Application Ref:	3/2021/0237	 <div>Ribble Valley Borough Council</div> <hr/> <div>www.ribblevalley.gov.uk</div>	
Date Inspected:	4/2/2021		
Officer:	BT		
DELEGATED ITEM FILE REPORT:		Decision	Refusal

Development Description:	Proposed raised roof to dormer bungalow to create full two storey dwelling and alteration to parking arrangements.
Site Address/Location:	3 Moor Field, Whalley. BB7 9SA

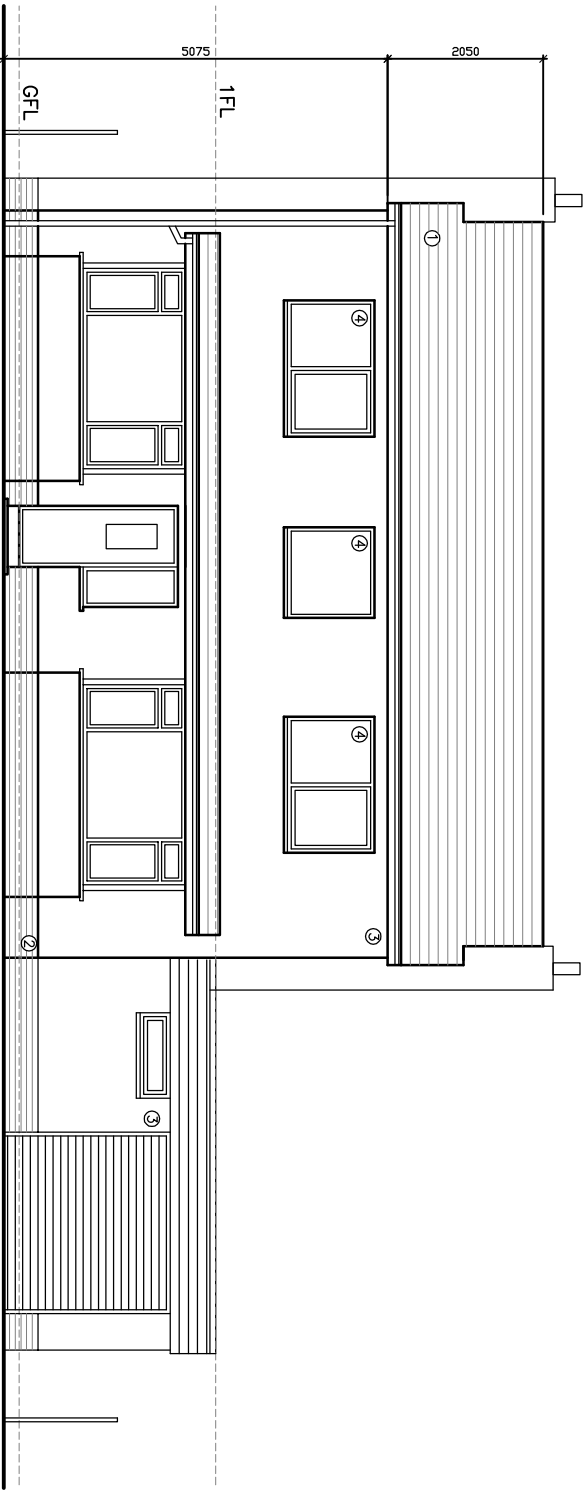
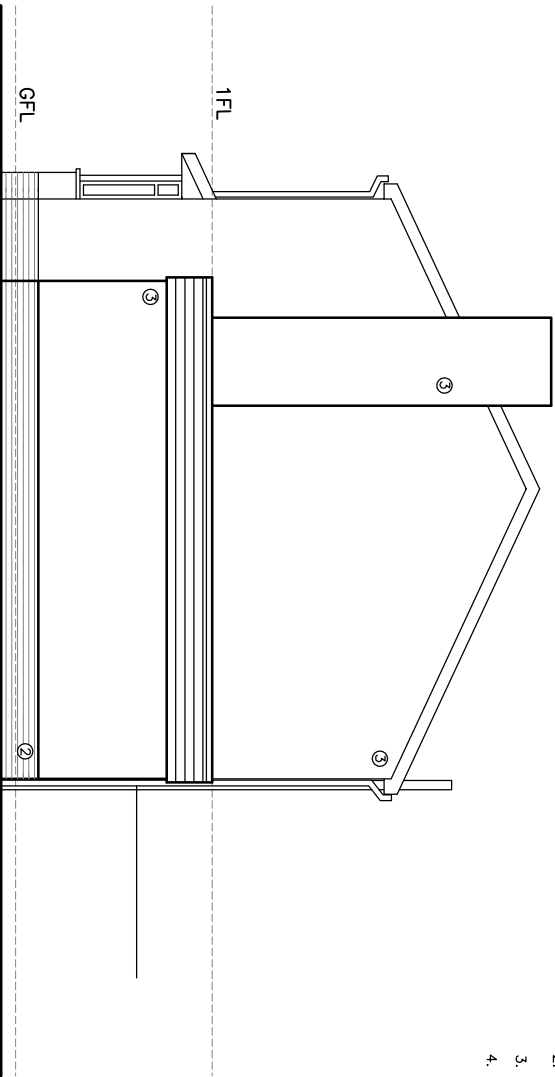
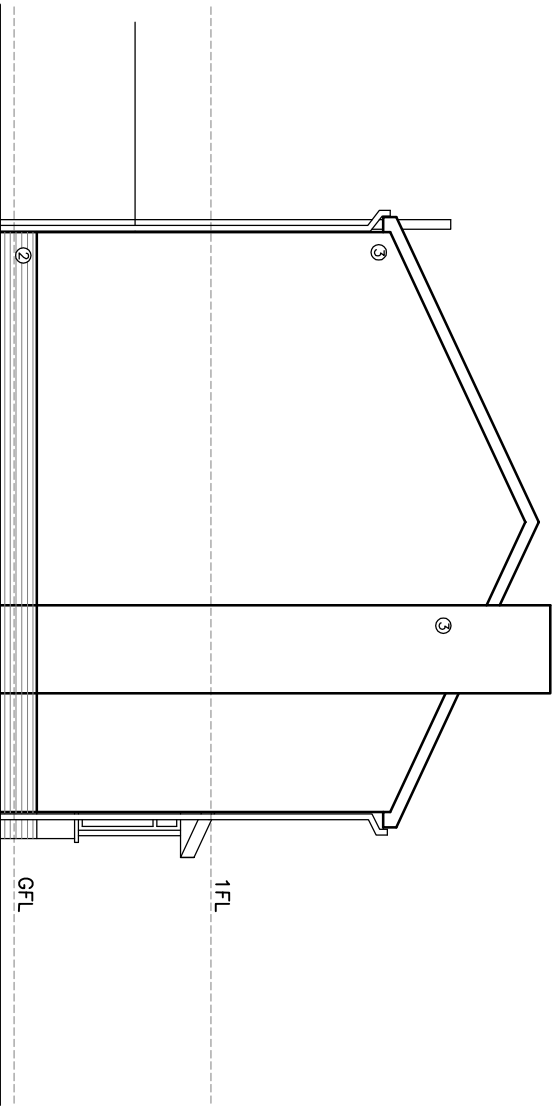
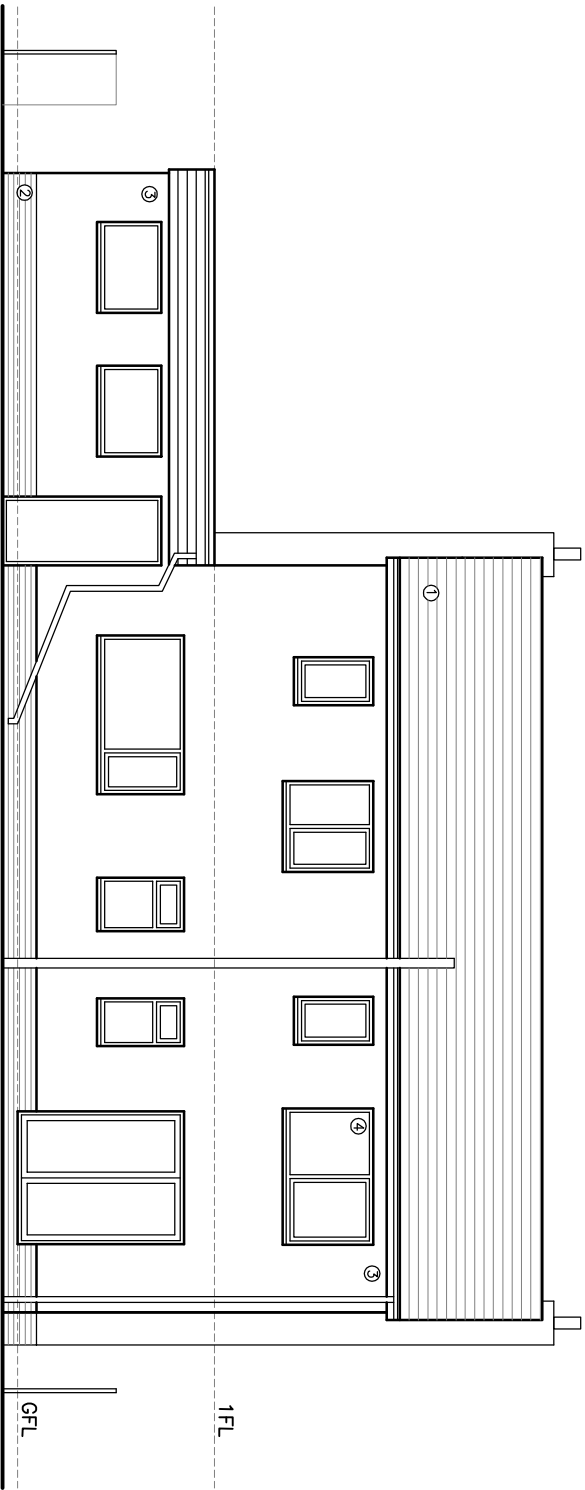
The proposal includes three first floor windows on its front elevation which will face towards properties on the opposite side of Moorfield. These windows will be sited in an almost identical position to the existing first floor windows and as such will not provide any new opportunities for overlooking into private areas.

The proposal also includes four first-floor windows on its rear elevation which will face towards the rear of properties on Mitton Road. Two of these windows will form part of habitable rooms which may allow a certain degree of overlooking into the rear gardens of No.1 and No. 5 Moorfield however the 15 metre distance and relatively obtuse angles between these windows and the neighbouring gardens is considered as sufficient enough to prevent any serious infringement of privacy.

The proposal involves an amendment to the property's existing roof which will raise the existing roof pitch by an additional 1.2 metres. This alteration could potentially affect the provision of natural light for the neighbouring property at No. 1 Moor Field which contains two ground floor windows and a first-floor bedroom window on its side elevation.

No. 3 Moor Field has an existing roof pitch height of 5.9 metres which would be increased to 7.1 metres as part of the proposal in order to convert the existing dormer bungalow property into a traditional two-storey dwelling.

As such, it is considered that the proposal would have a significant visual impact by virtue of its increased roof pitch height which would be at odds with the lower roof pitch heights of No. 1 and No. 5 Moor Field which are situated either side of No. 3 Moor Field.

Policy DMG1 of the Ribble Valley Core Strategy states that development must '*not adversely affect the amenities of the surrounding area*' however in this instance it is considered that the proposed works would have an adverse visual impact upon the existing street scene through significantly disrupting the ascending roof scape which currently runs along the Western side of Moor Field.

As such, it is considered that the proposal would have an adverse impact upon visual amenity by virtue of the proposed alterations to the property's existing roof pitch which would ultimately result in the creation of a dwelling that would not be in keeping with the existing pattern of housing on Moor Field.

The proposal, by virtue of the proposed roof alterations, would result in the introduction of an incongruous, anomalous and discordant form of development that fails to respond positively to the inherent character of the immediate roofscape and street scene, being of significant detriment to the character and visual amenities of the area. As such the proposal is considered to be in direct conflict with Policies DMG1 and DMH5 of the Ribble Valley Core Strategy.

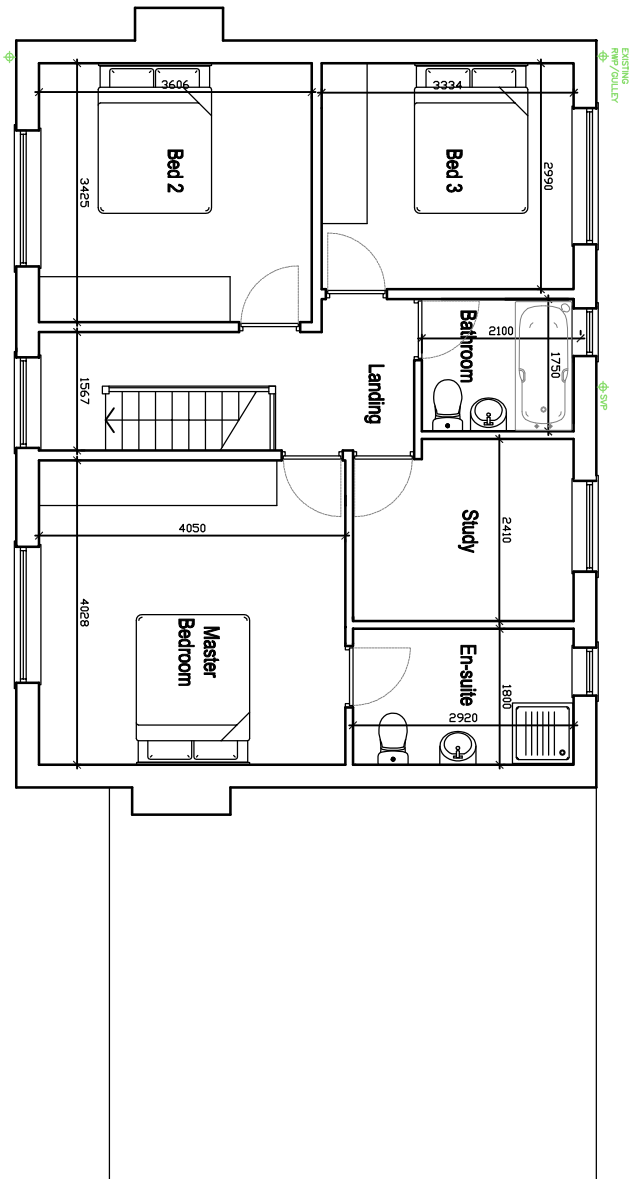
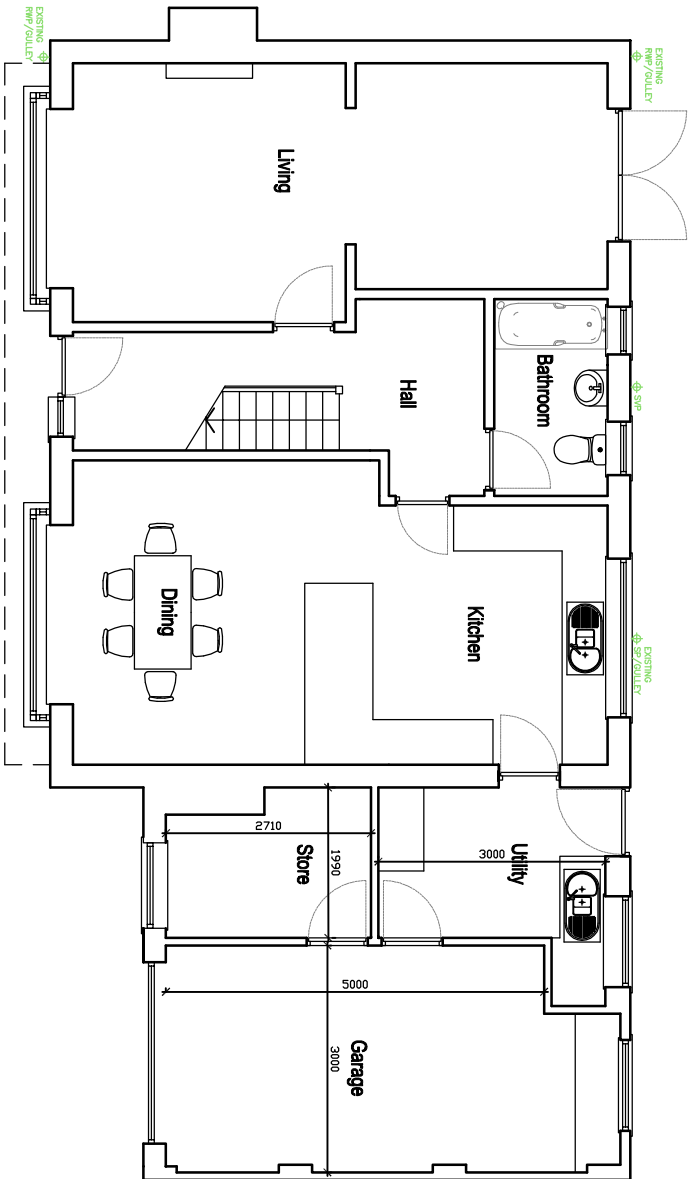
Lancashire County Council Highways have not been consulted on the proposal however the loss of an off-street parking space through the proposed internal alterations to the property's existing garage will be mitigated through the creation of an additional parking space within the property's front driveway. As such, it is not considered that the proposed works will lead to any adverse impact upon highway safety.
